Recommendation Report for Planning Permission for Works or Extension to a Dwelling

REF NO: WA/44/22/HH

LOCATION: Westing House
Barnham Lane
Walberton
BN18 0AZ

PROPOSAL: Removal and erection of detached garage and single storey rear extension.

sheet 1 of 3

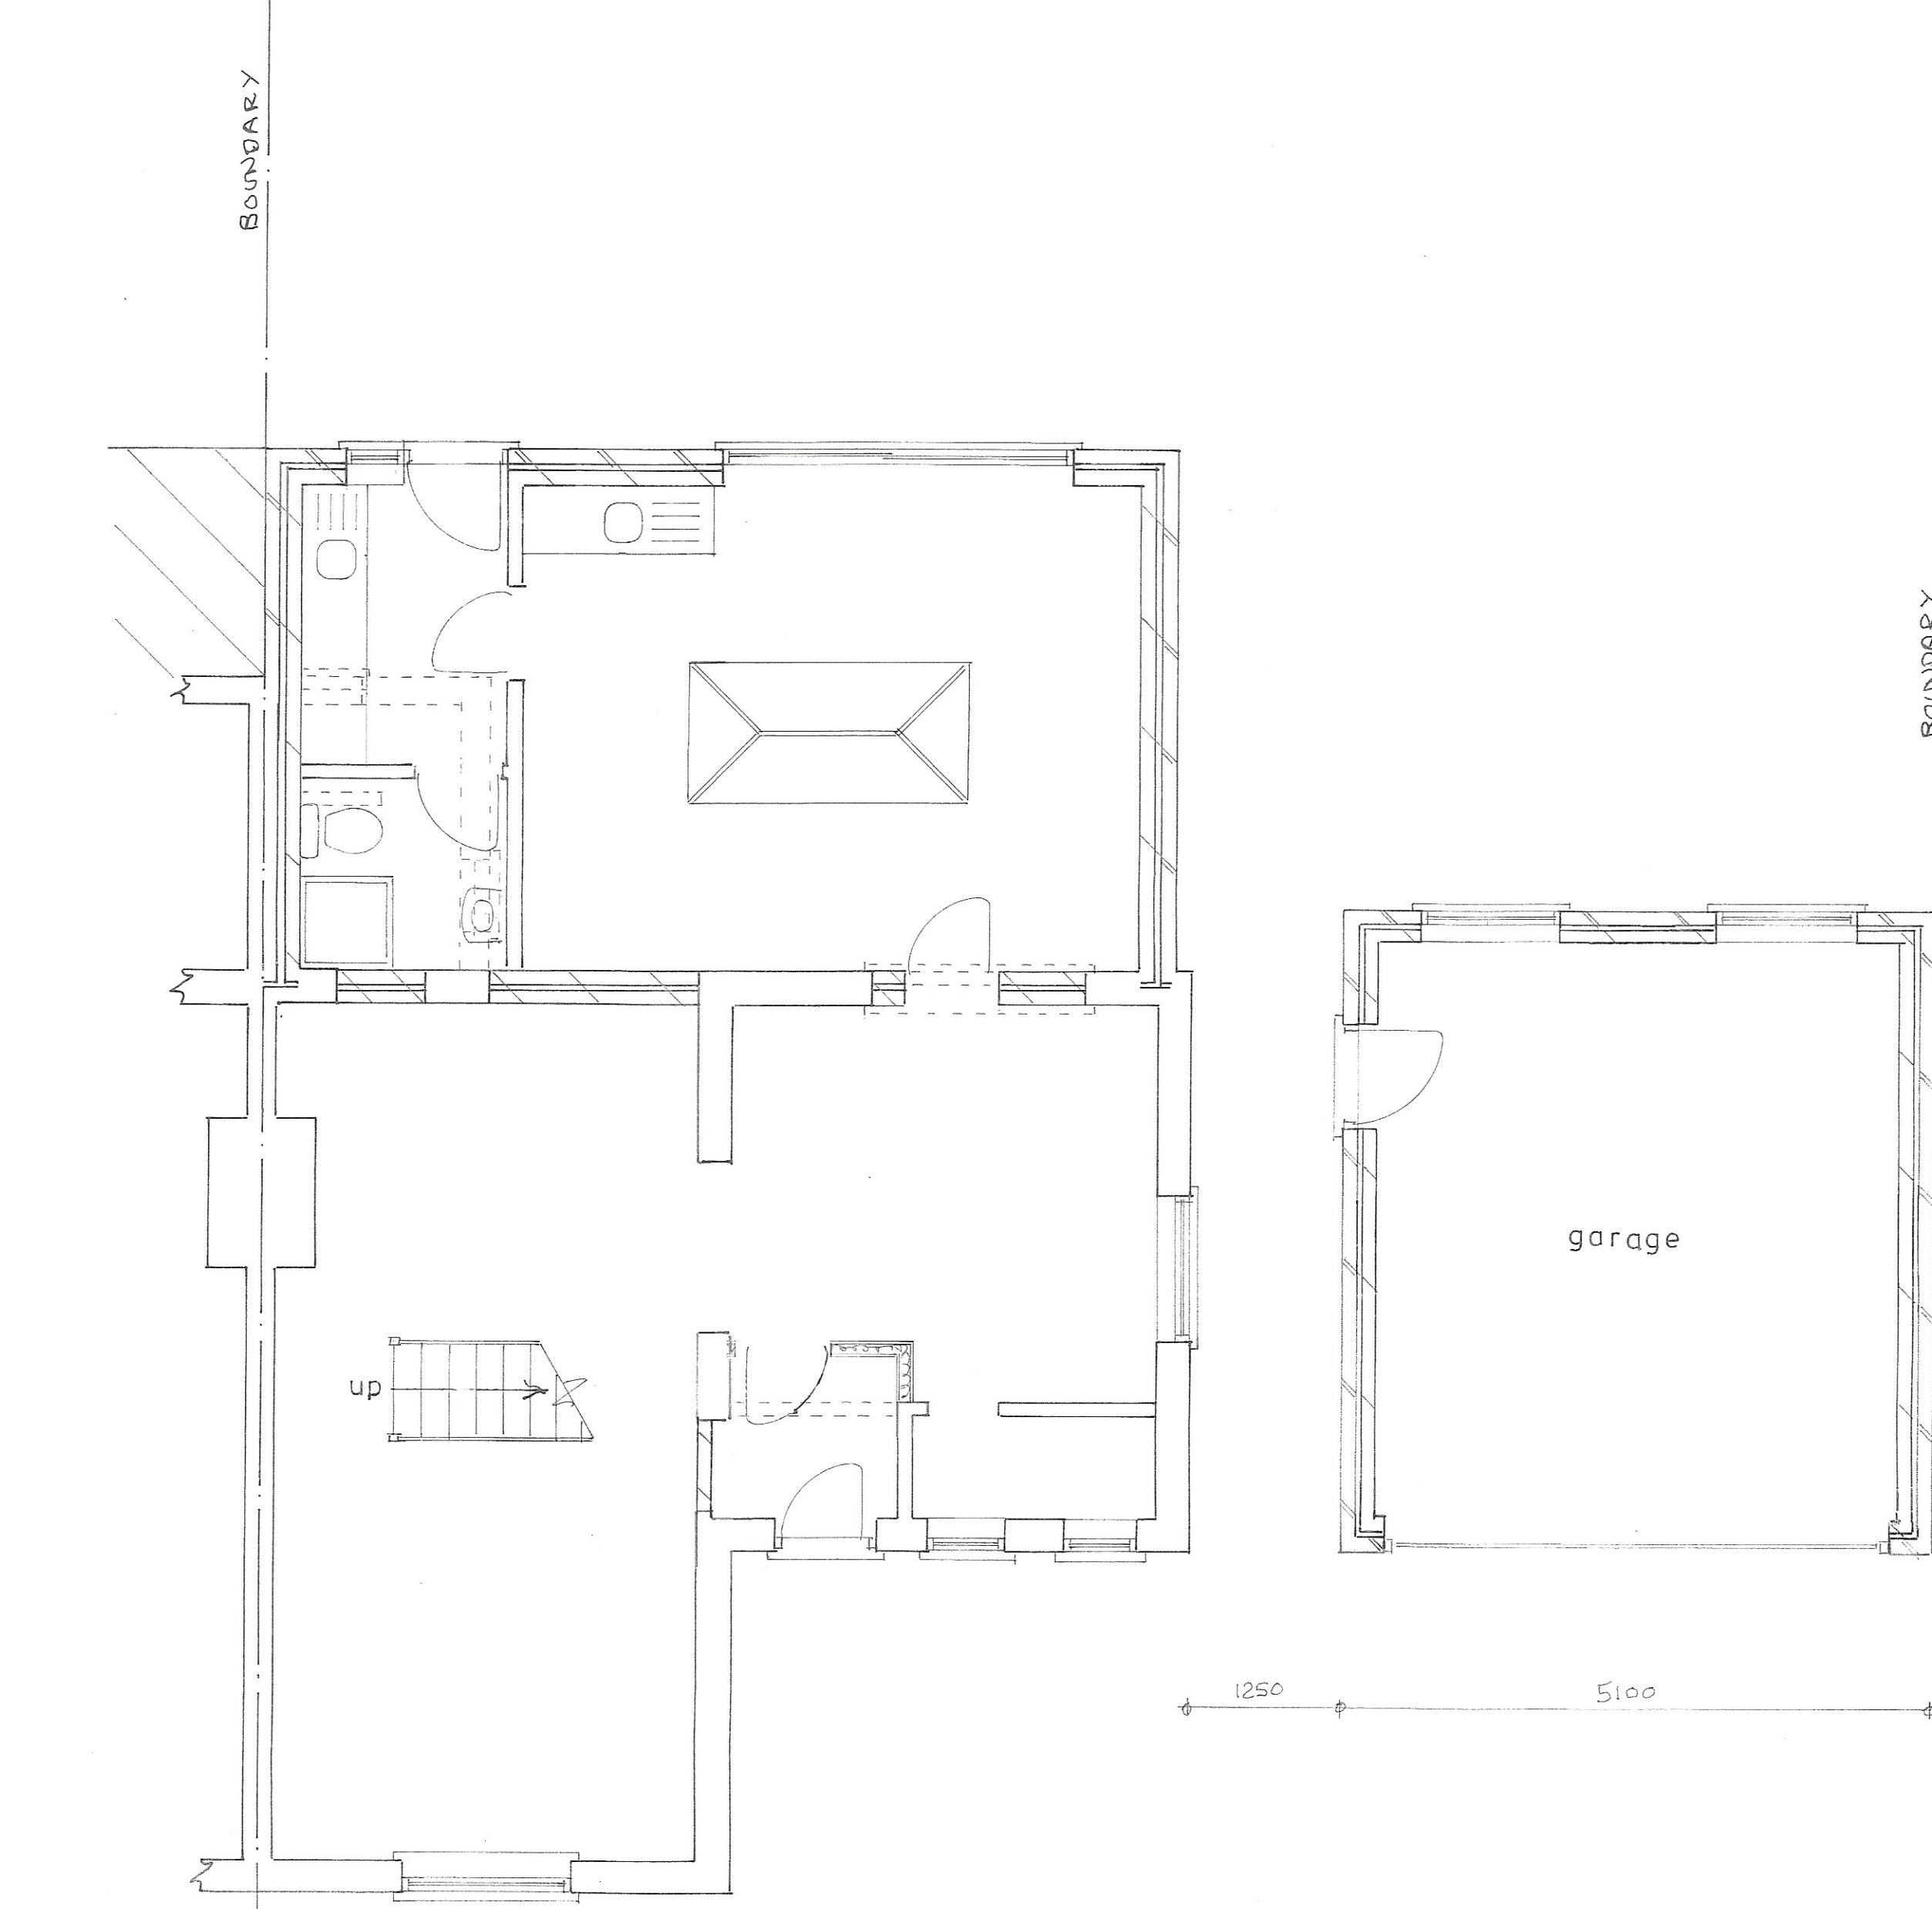
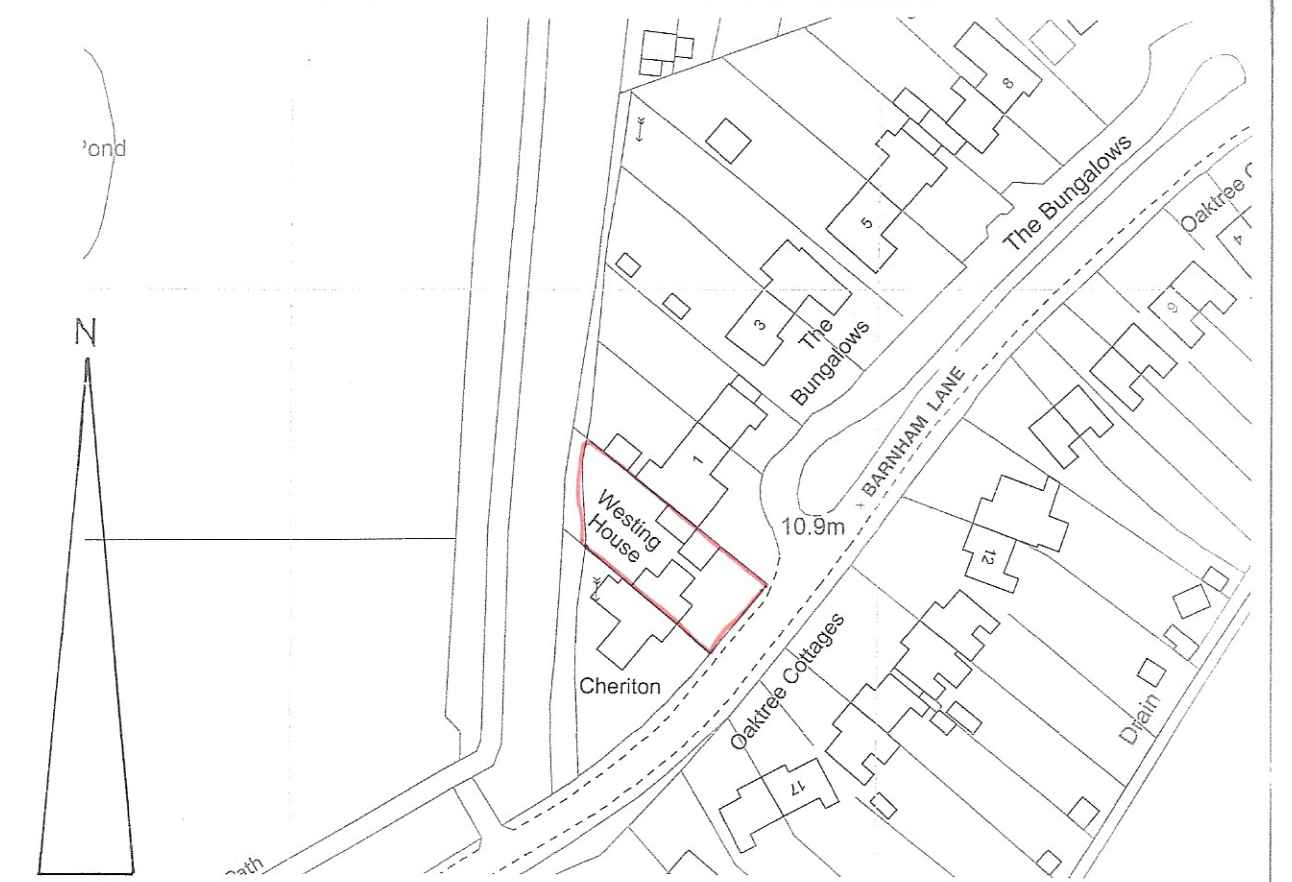
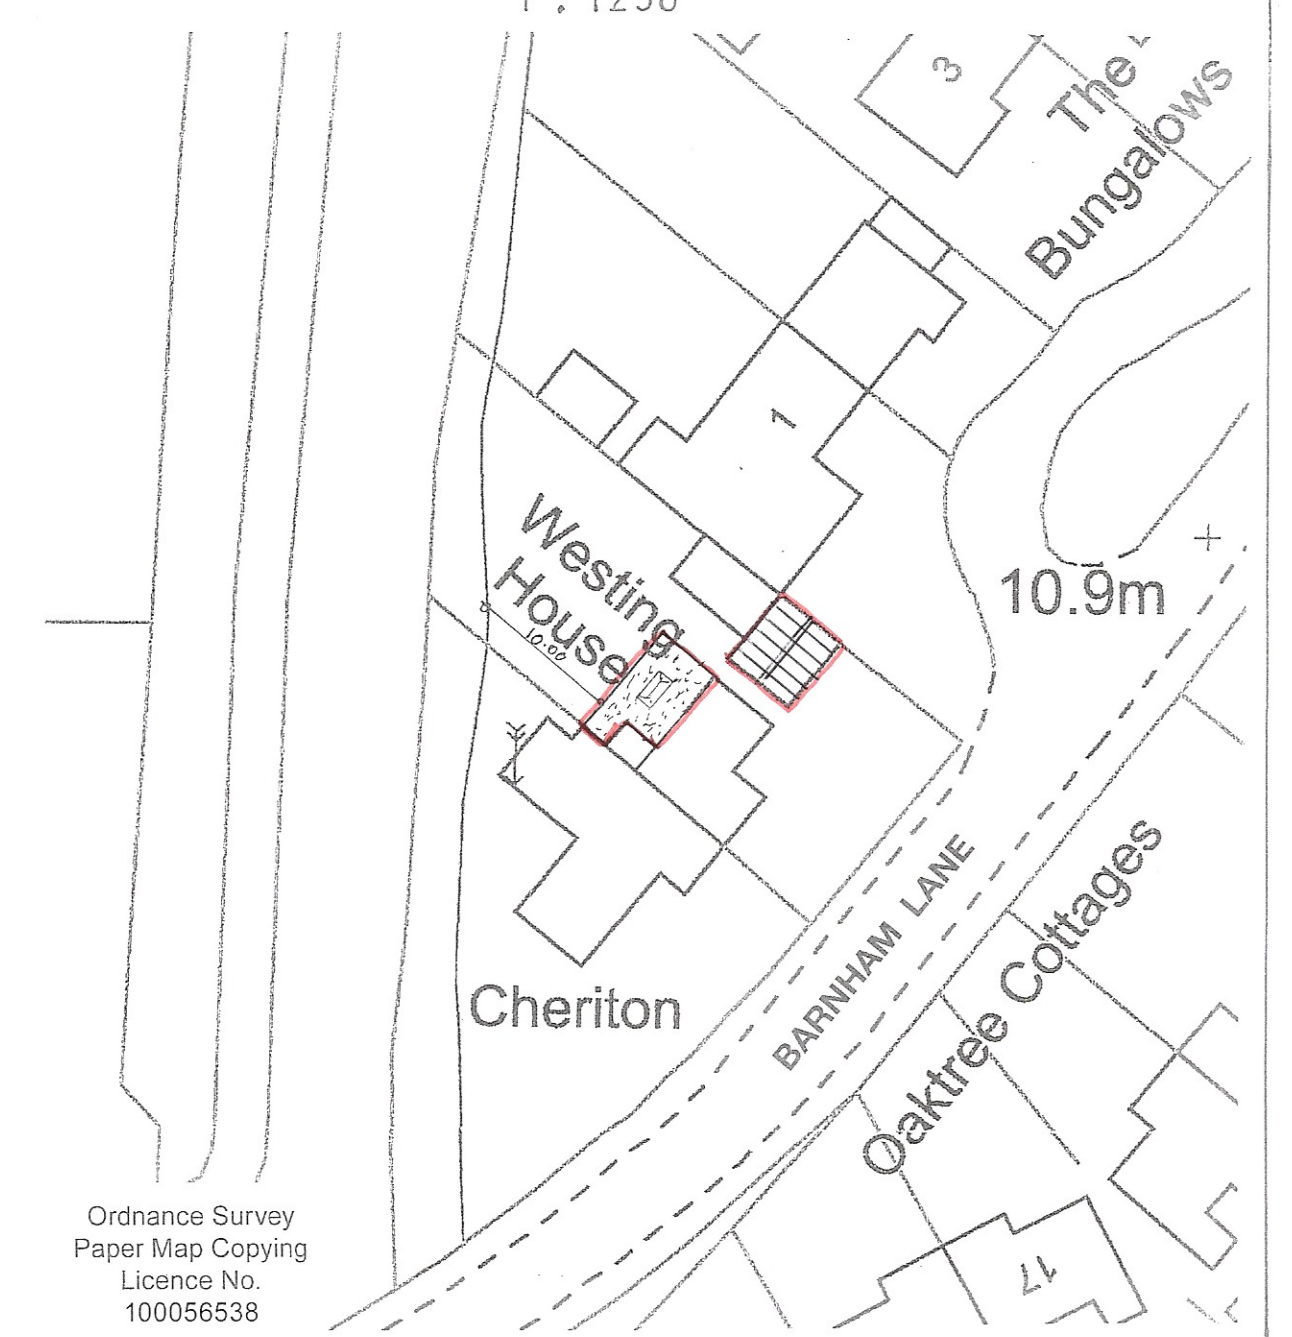
The proposed replacement garage would feature a significant increase in height of approx. 2.2m to feature its pitched roof design. The neighbouring property, 1 The Bungalows, is set back from Westing House and the siting of the detached garage is such that the height of the roof would be a noticeable visual change at the front of the property. There exists soft boundary treatment including a tree between the two properties which would obscure the view of the detached garage to a degree. However, the garage would cause some level of overshadowing and overbearing on the front elevation at 1 The Bungalows. The levels of overshadowing and overbearing impacts are not significantly adverse and as such, are not grounds for refusal.

The proposed rear extension is of a scale that does not intersect any 60- degree or 45- degree sightlines/light accessibility lines and as such, gives no rise to any adverse impacts by way of overbearing or overshadowing on any neighbour dwellings. There are to be multiple new viewpoints to the rear of the extension however, they look out to the rear amenity space and give no rise to any adverse impacts by way of overlooking.

sheet 2 of 3

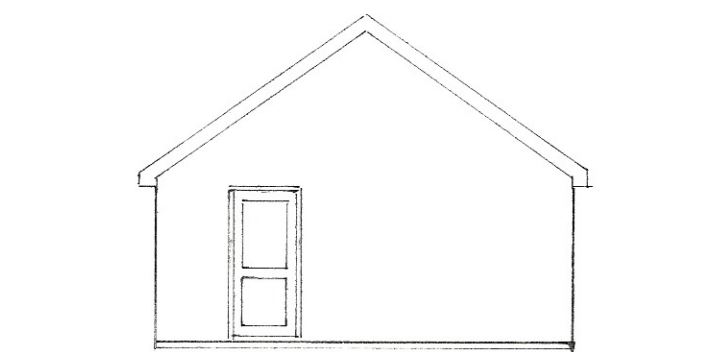
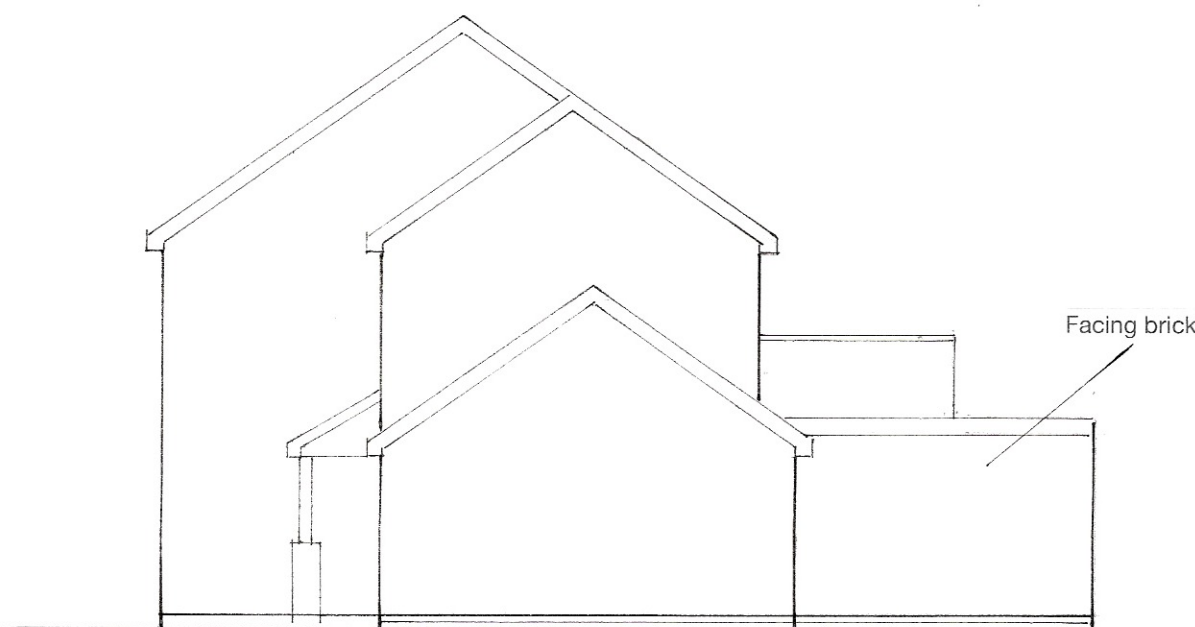
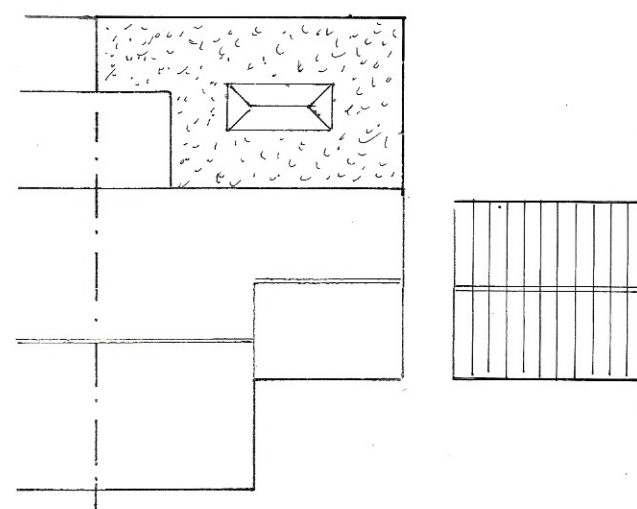
The proposed replacement detached garage is to be 5.1m in width, equal to that of the existing, but approx. 5.6m in depth which is an approx. 0.6m increase. This replacement garage would also feature a pitched roof design that reaches a peak height of approx. 4.5m with eaves at

approx. 2.4m. The scale of the replacement garage is similar in footprint with a higher roof. The scale of the detached garage is visually subservient to the host dwelling and is to be constructed from materials matching those found on the existing dwelling. The pitched roof also matches the pitch of the host dwelling.

The proposed single storey rear extension is to be approx. 4.5m in depth, 7.85m in width, and 2.8m in height. The scale of the rear extension would be visually subservient and integrated with the host dwelling, featuring a flat roof design and matching materials to those of the host dwelling.
